***Adaptive Reuse of the Clare Hotel and
Administration Building on Block 3A***

***Central Park, Chippendale
(Former Carlton United Brewery)***

MP 11_0089 - Modification 1

Director-General's
Environmental Assessment Report
Section 75W of the
Environmental Planning and Assessment Act 1979

1 LEVEL 3
1:100

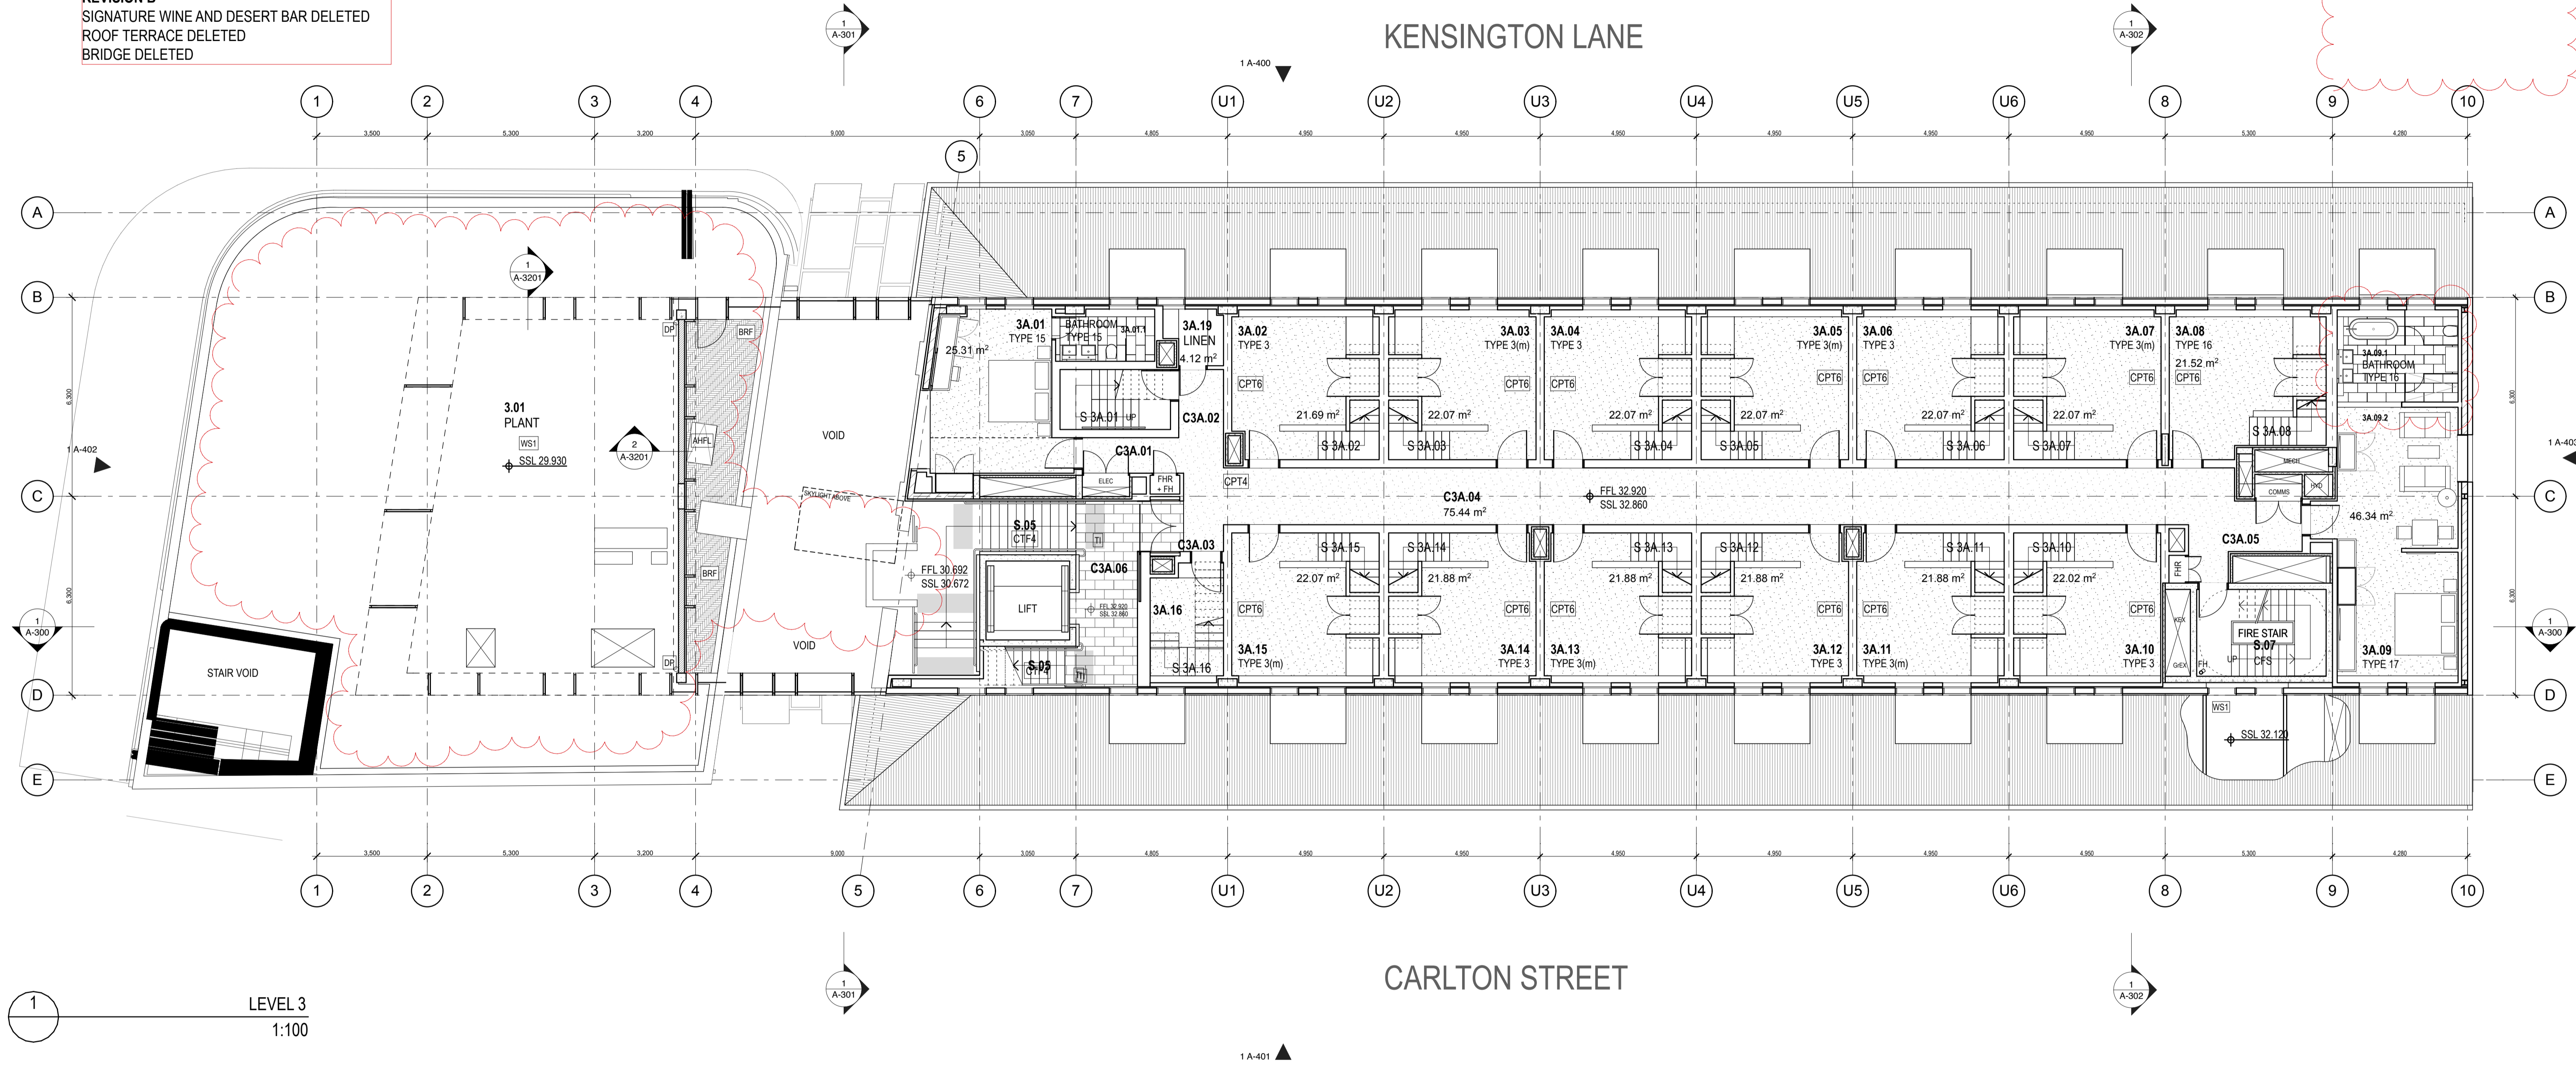
The wine and dessert bar on Level 3 is to be deleted as part of the proposal and the department raises no concern as it is an internal design change that results in no additional environmental impact.

The approved project included construction of a through link bridge between the existing Clare Hotel building and the Administration Building. The proposal seeks to delete this link bridge at Level 3, (see **Figure 2**). In the project approval the department noted the link bridge to be the main external impact to the existing buildings at street level. As the removal of the bridge link would eliminate this impact, the department does not have any concerns with the deletion of this link.

1 ROOF
1:100

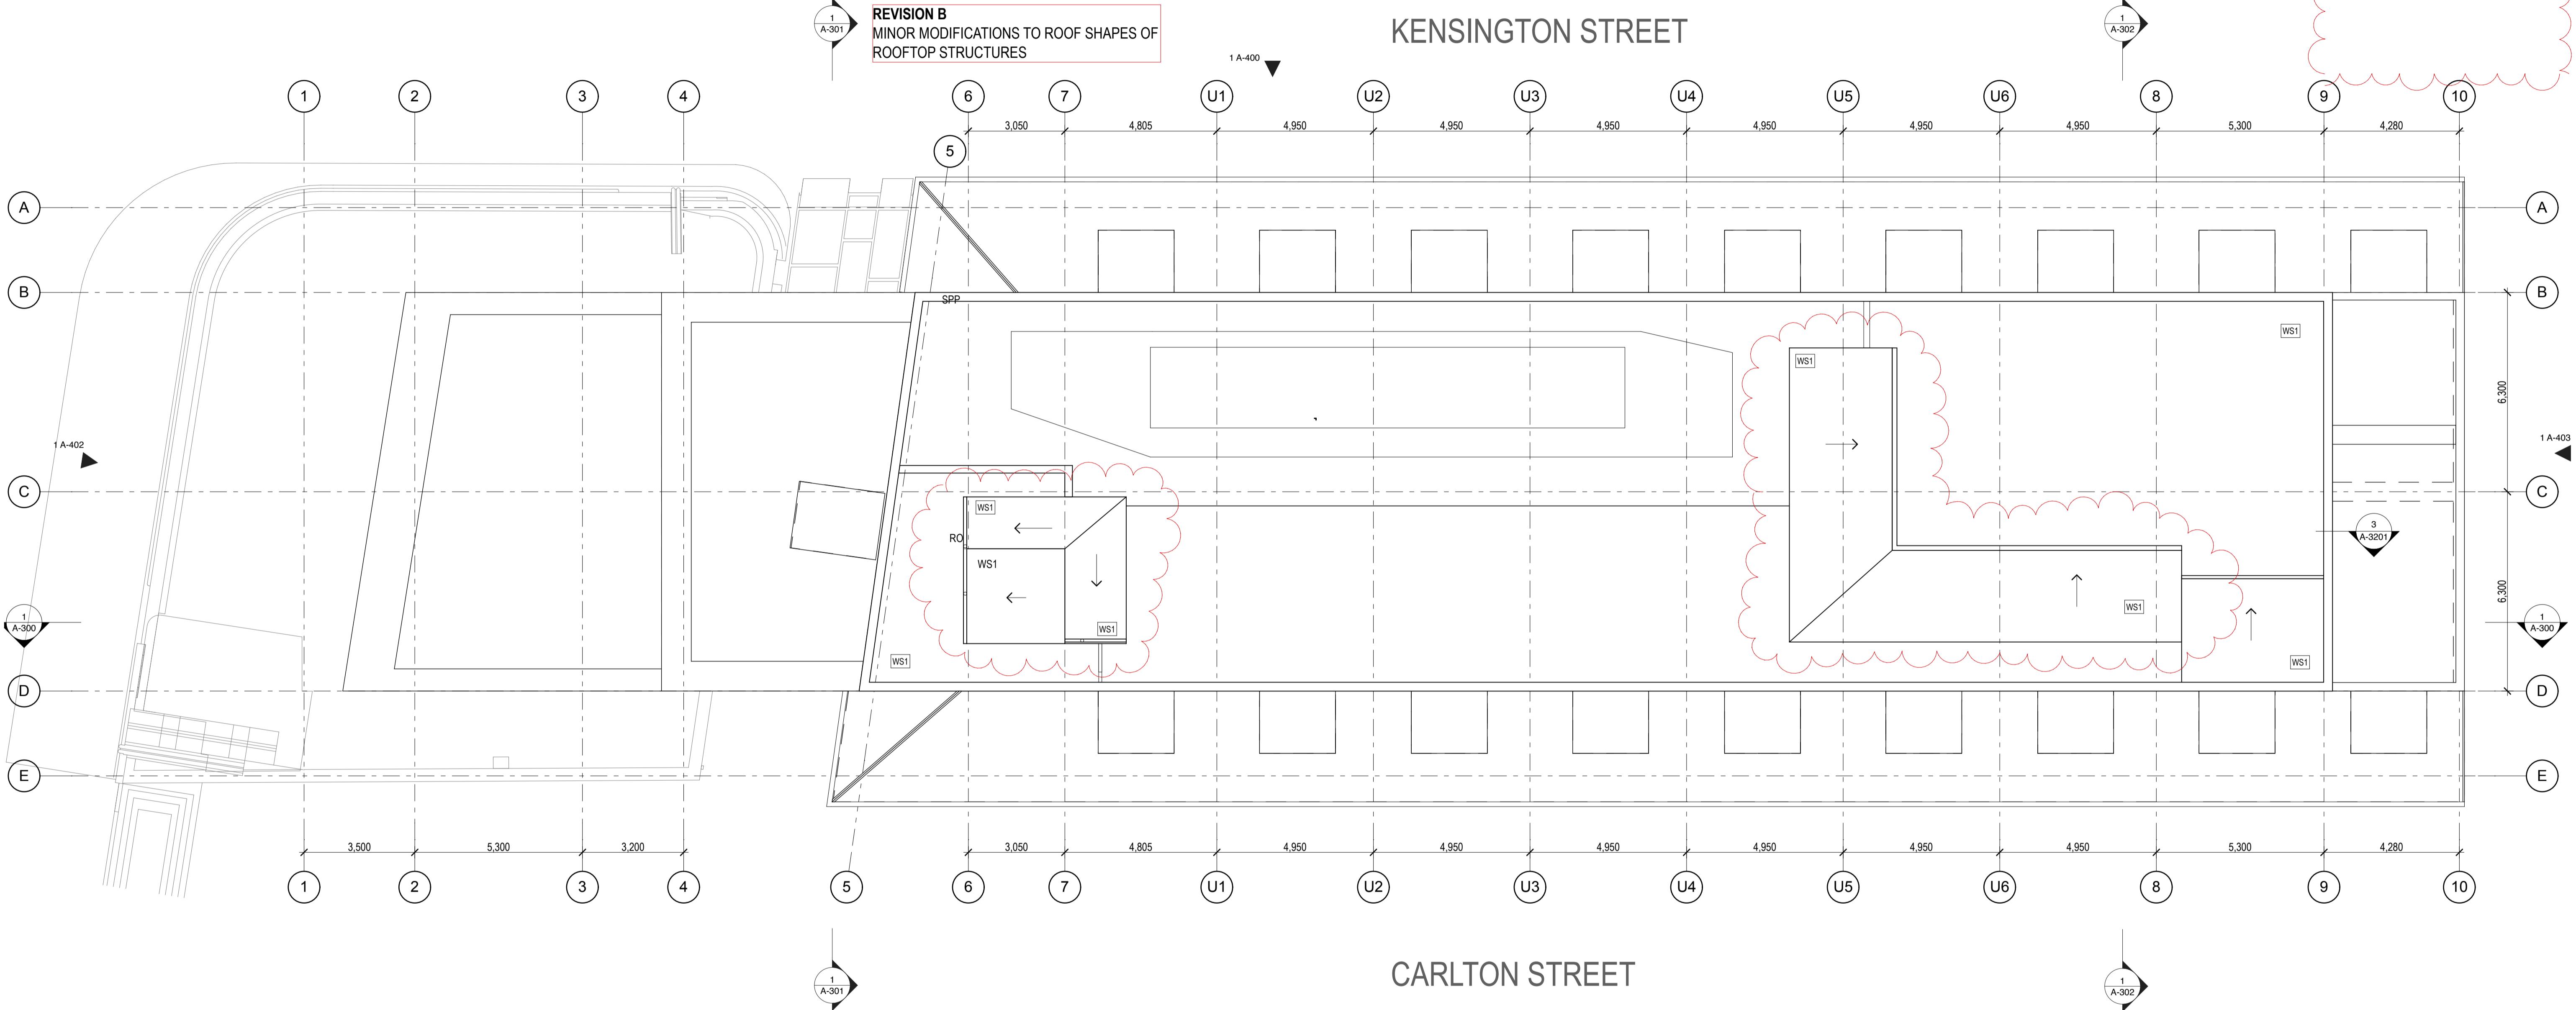
- relocating the pool to the east side of the roof;
- increasing the pool deck roof canopies by 100mm;
- material changes to façade in-fill and lift overrun;
- pattern modified to façade;
- addition of mechanical louvers; and
- alterations to western entry canopy.

1 SECTION 01
 1:100

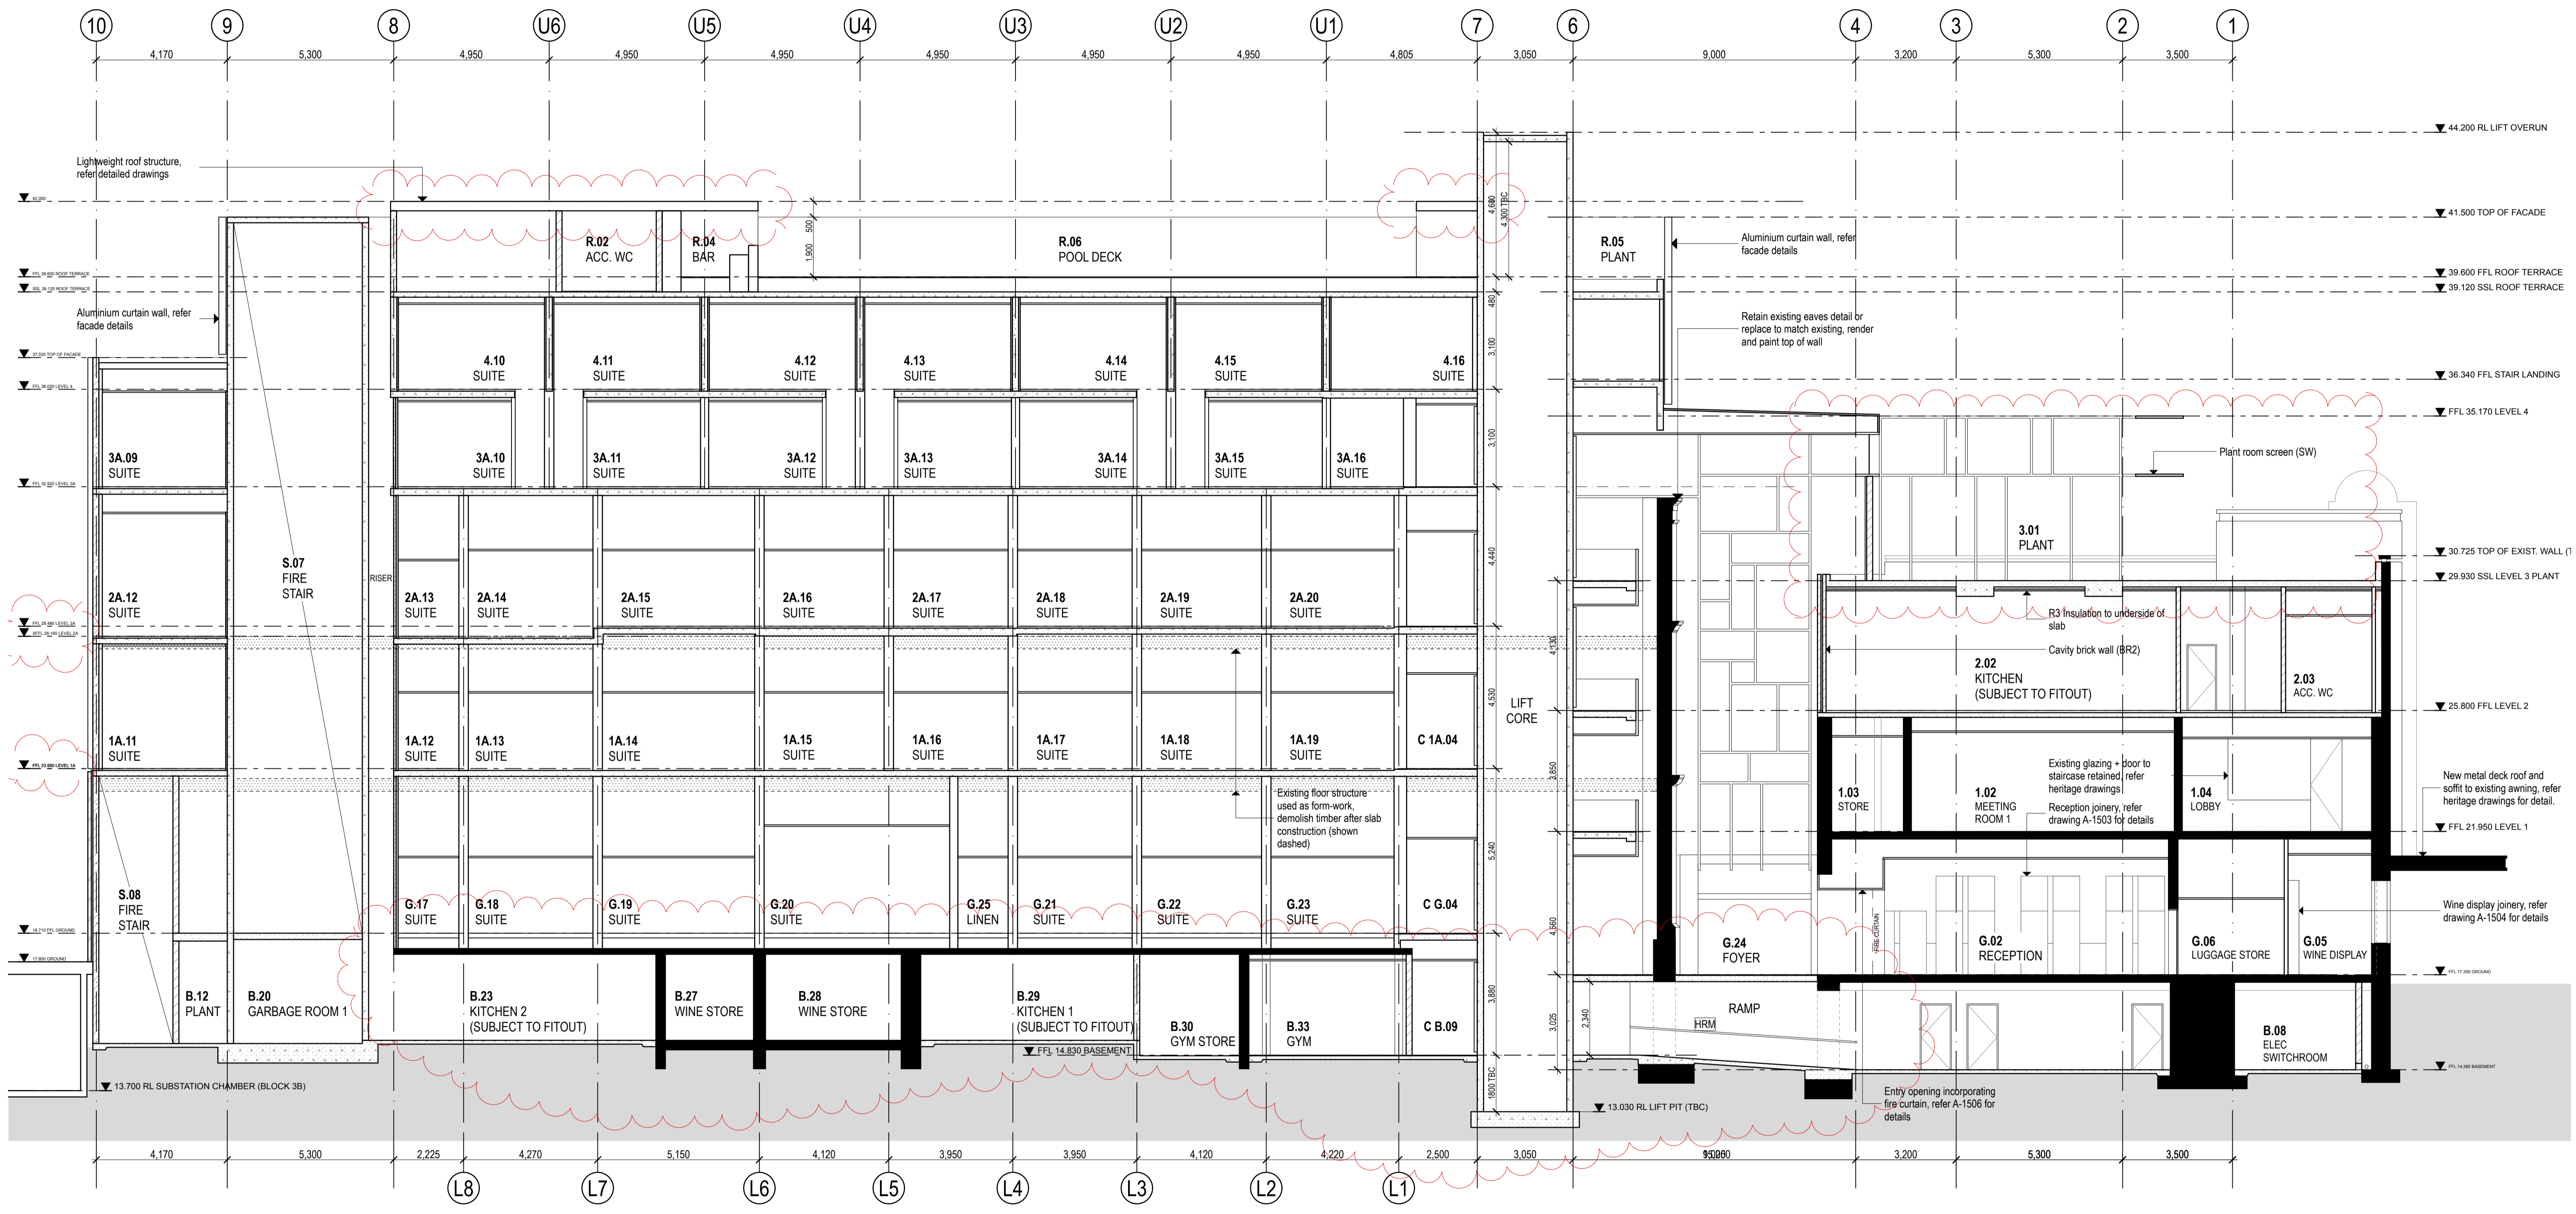
The proposed increase of 100mm to the pool deck roof canopies would change the maximum height of the development from RL 41.9 to RL 42.
